From:
Sent: 19 September 2023 20:43
To: Victor Grayson
Subject: 2023/92255,2023/92327,2023/92254,2023/92253

Comments in relation to the following applications by Newett Homes:

2023/92255 Land at Green Acres Close, Emley, Variation of Conditions 1 (Plans) , 2 (Crime Prevention) and 15 (Permitted Development) of Previous reserved matters approval 2021/93286 pursuant to outline permission 2020/91215

2023/92327 Land at Green Acres Close – modified plans for 6 Dwellings plus parking and landscaping and modified plans for ball stop netting.

Project		Residential Development of Wentworth Drive, Emley	
Client		Barratt Homes	
Drawing		Section 104 Layout	
Drawn By:	TM	Date:	05/01/2022
Checked:	GS	Scale:	1:250
Drawing No:	AMA/21311/D/500	Rev:	P6

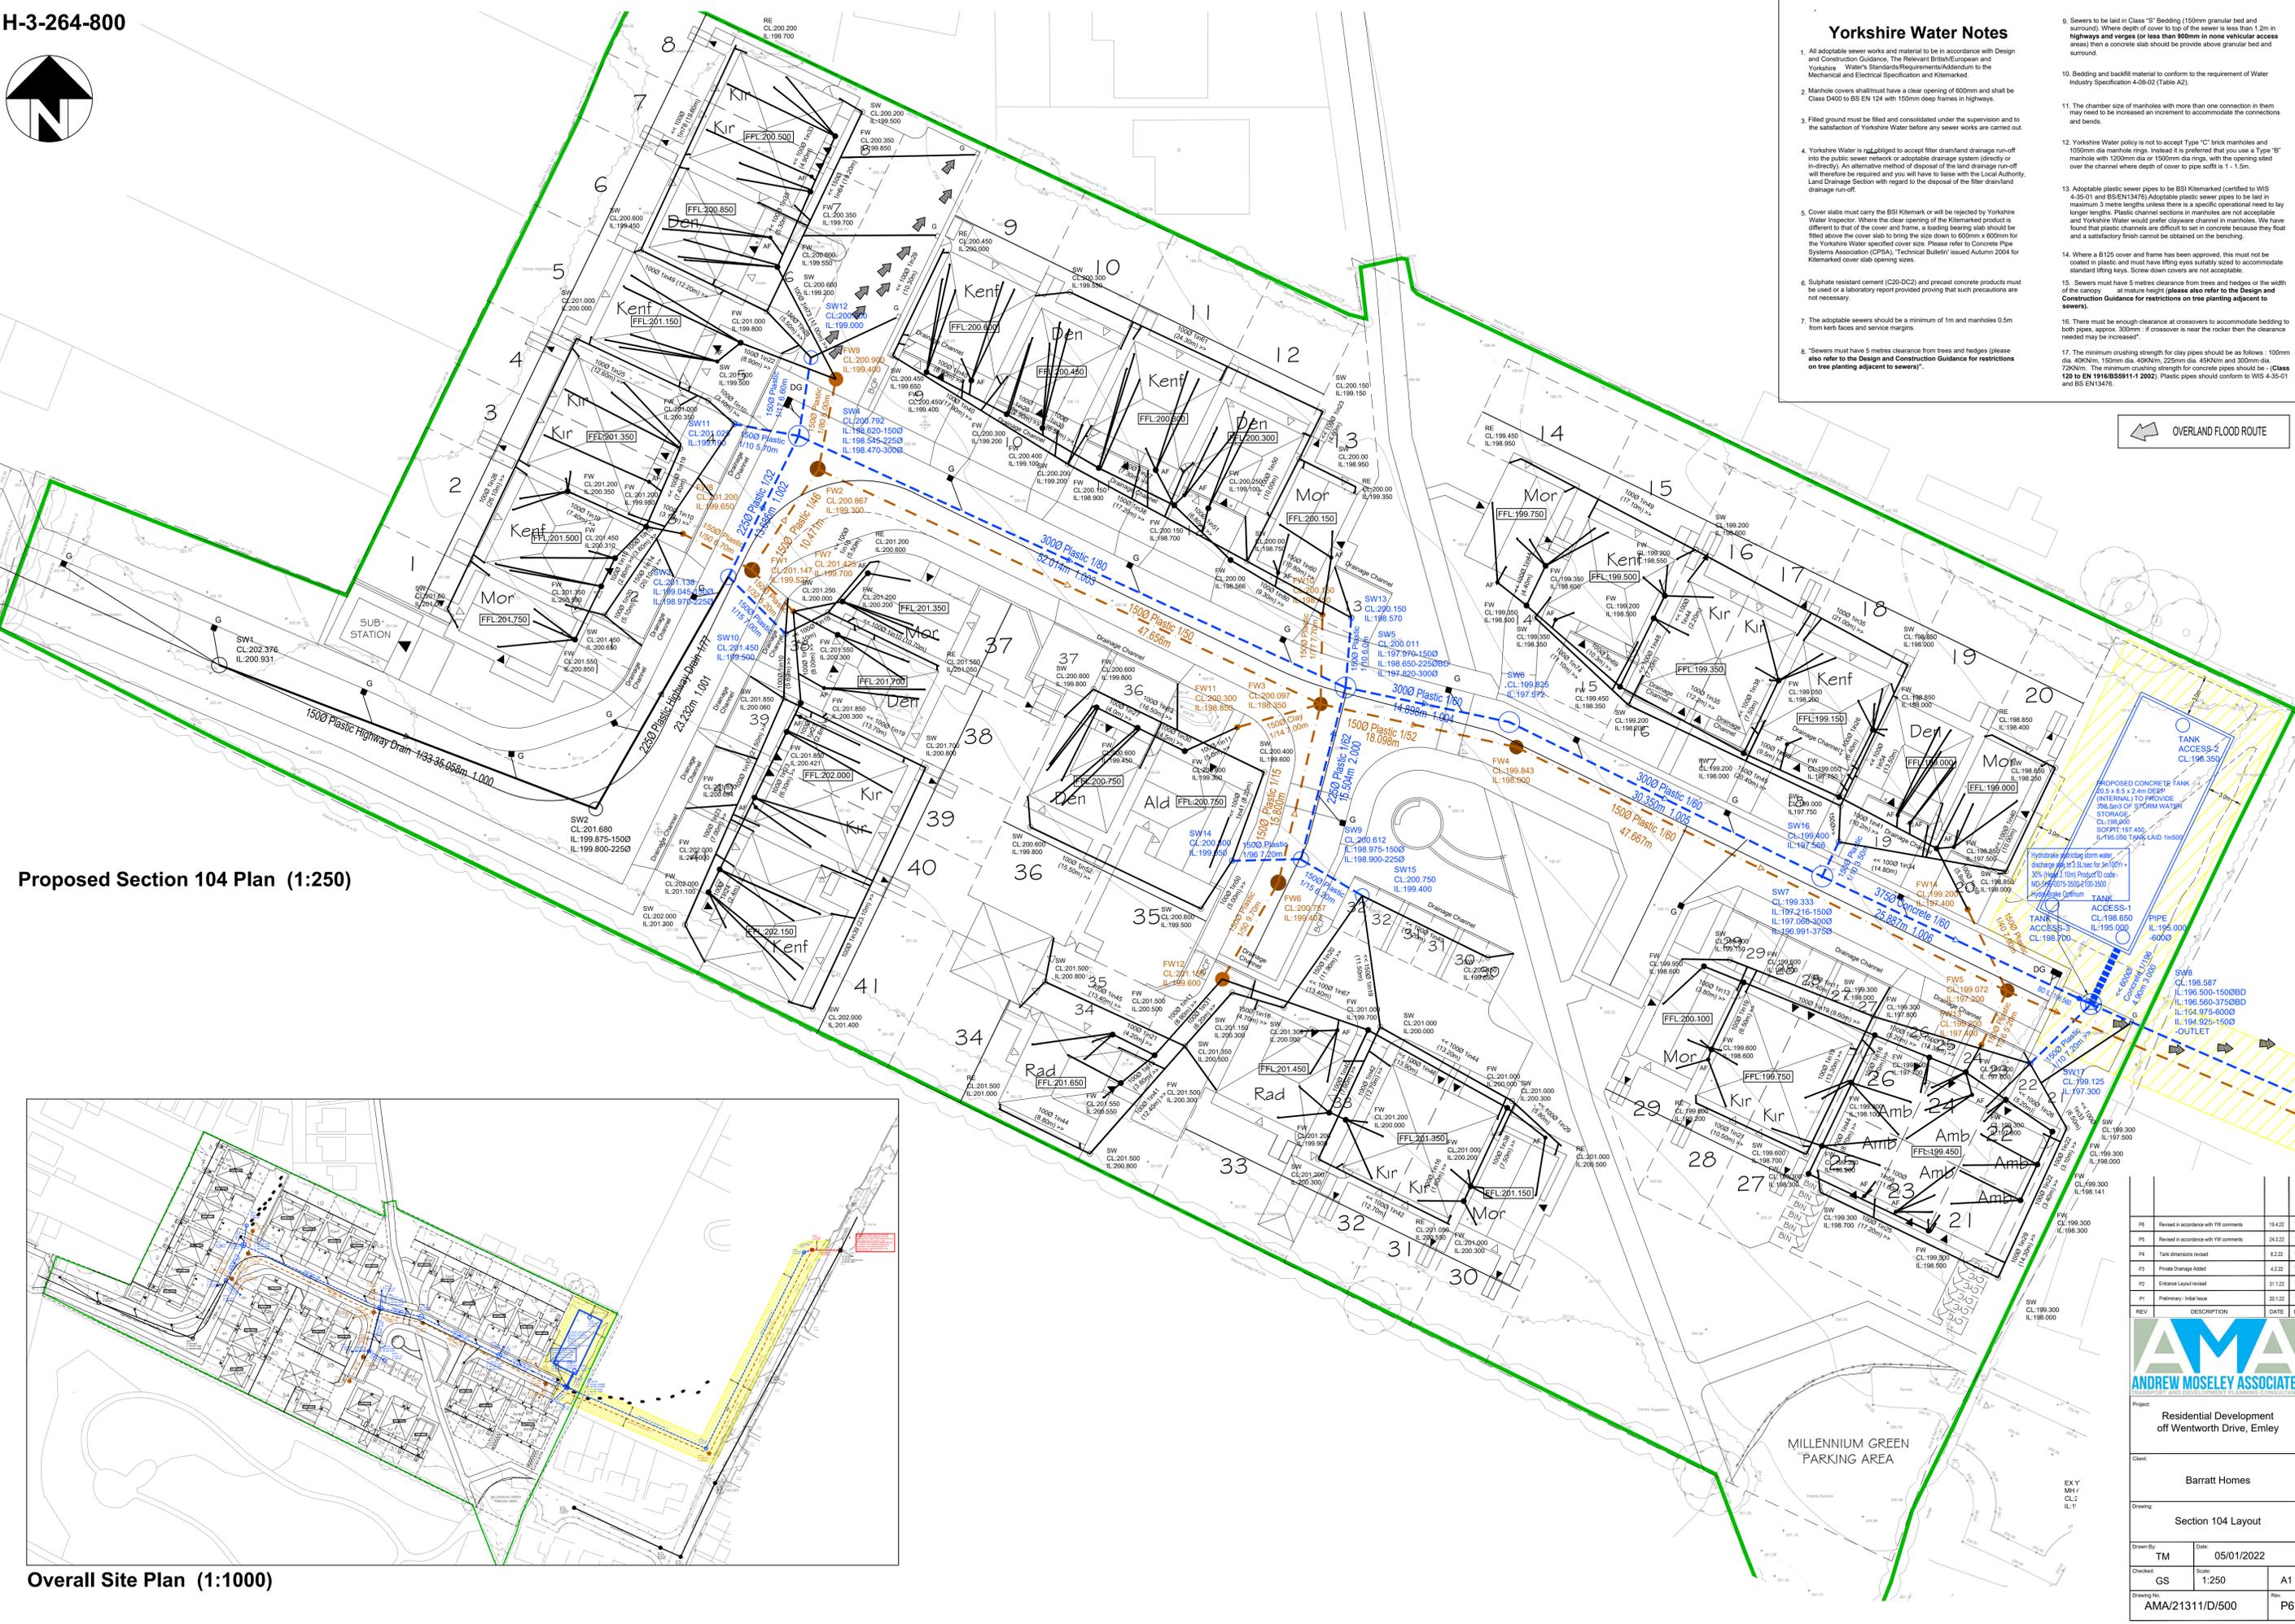
Newett Homes have submitted plans for temporary drainage that will affect the parking area and entrance to the Emley Millennium Green – Any drainage plans that affect the parking area or entrance must be discussed and agreed with the Trustees of the Green and must not block or impede the area at any time.
